**Our Case Number:** ACP-323996-26

**Re:** Proposed development N70 Waterville to Ballybrack Road Improvement Scheme  
Townlands of Waterville, Ballybrack and Eightercua, Co. Kerry

Your Ref: ACP-323996-26  
DAU Ref: S177AE N70 Waterville to Ballybrack Road KY  
(Please quote in all related correspondence)

**Re: Section 177AE application for N70 Waterville to Ballybrack Road Improvement Scheme in County Kerry**

Figure 5-11 Bridge Construction

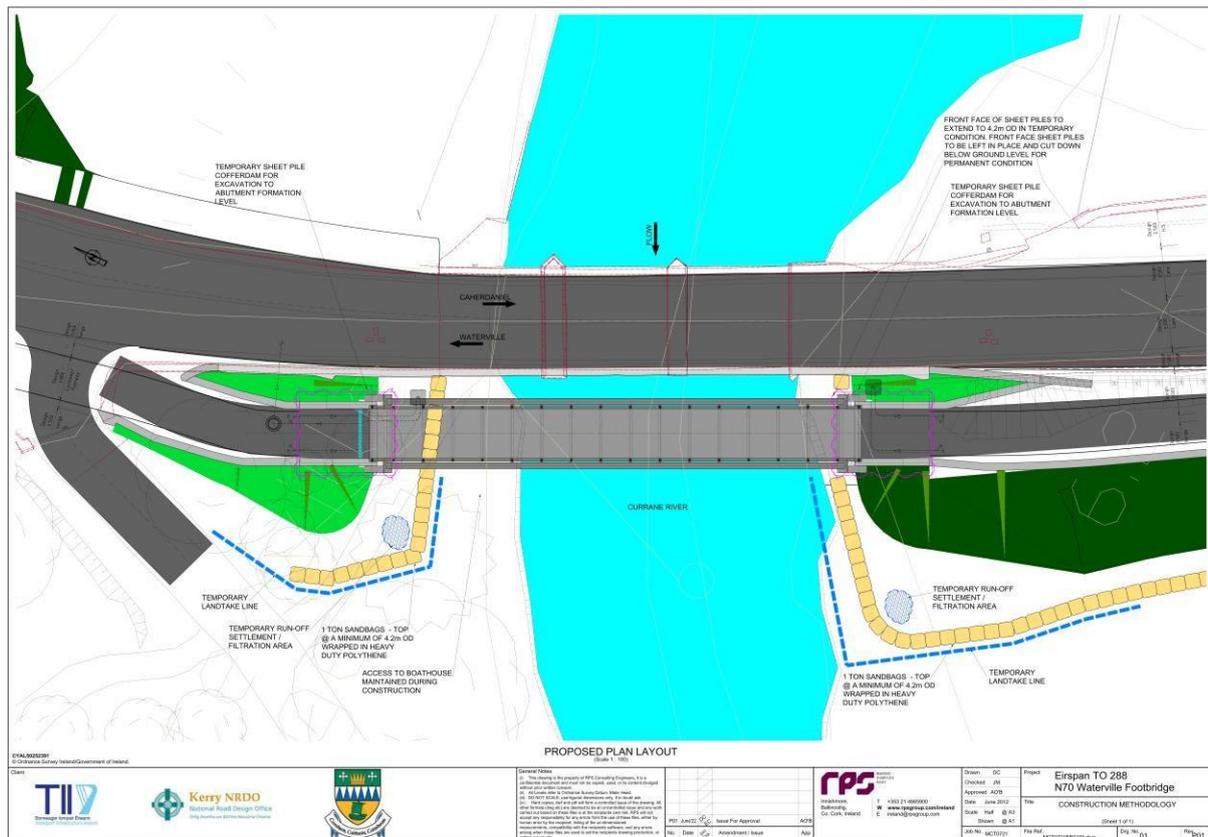
It is important that the measures necessary to avoid siltation from construction and road pollutant run-off during operation are fully implemented. In particular, as timing of works is not specified in the Natura Impact Statement (NIS), and as the bridge abutment sand-bags are to be placed in a flood zone, there may be a risk of sand-bag erosion. It is therefore important that the sand-bags are reinforced if necessary, and subject to inspection by a professional engineer before works commence. Also, regular maintenance of hydrocarbon interceptors (above the road drain discharge to the Currane River) is important.

*Figure 11-1 Built Heritage Sites*

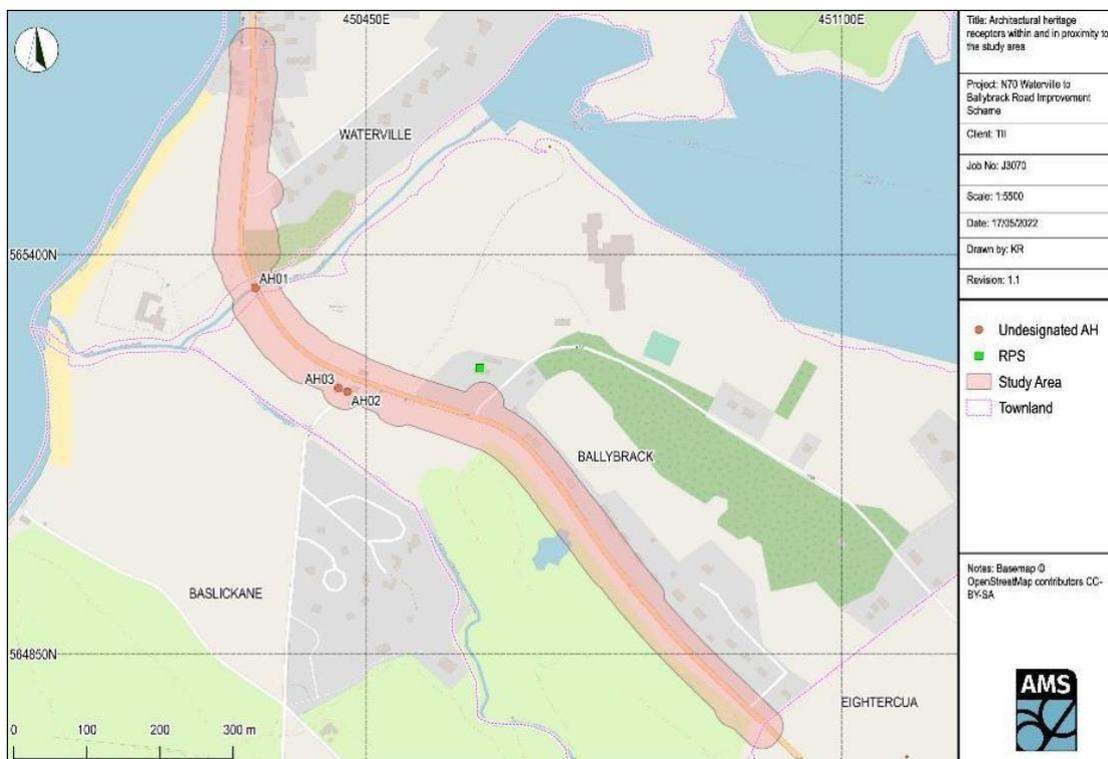
It is noted that the Planning and Environmental Considerations Report (PECR) includes a very brief summary assessment only of the likely archaeological and cultural heritage environment, potential effects of the project and proposed mitigation measures (Chapter 11). The PECR states that:

However, this assessment was not included in the Application documents either as a supporting appendix to the PECR or as a standalone document. Therefore, the Department advises that the Applicant must be requested to provide a copy of the full Cultural Heritage Impact Assessment (and any other relevant documentation omitted from the Application). The full assessment is needed in order to properly evaluate the proposed development and to support informed decision-making. The Department advises that no decision be made on

this application until the full Cultural Heritage Impact Assessment has been reviewed and evaluated.
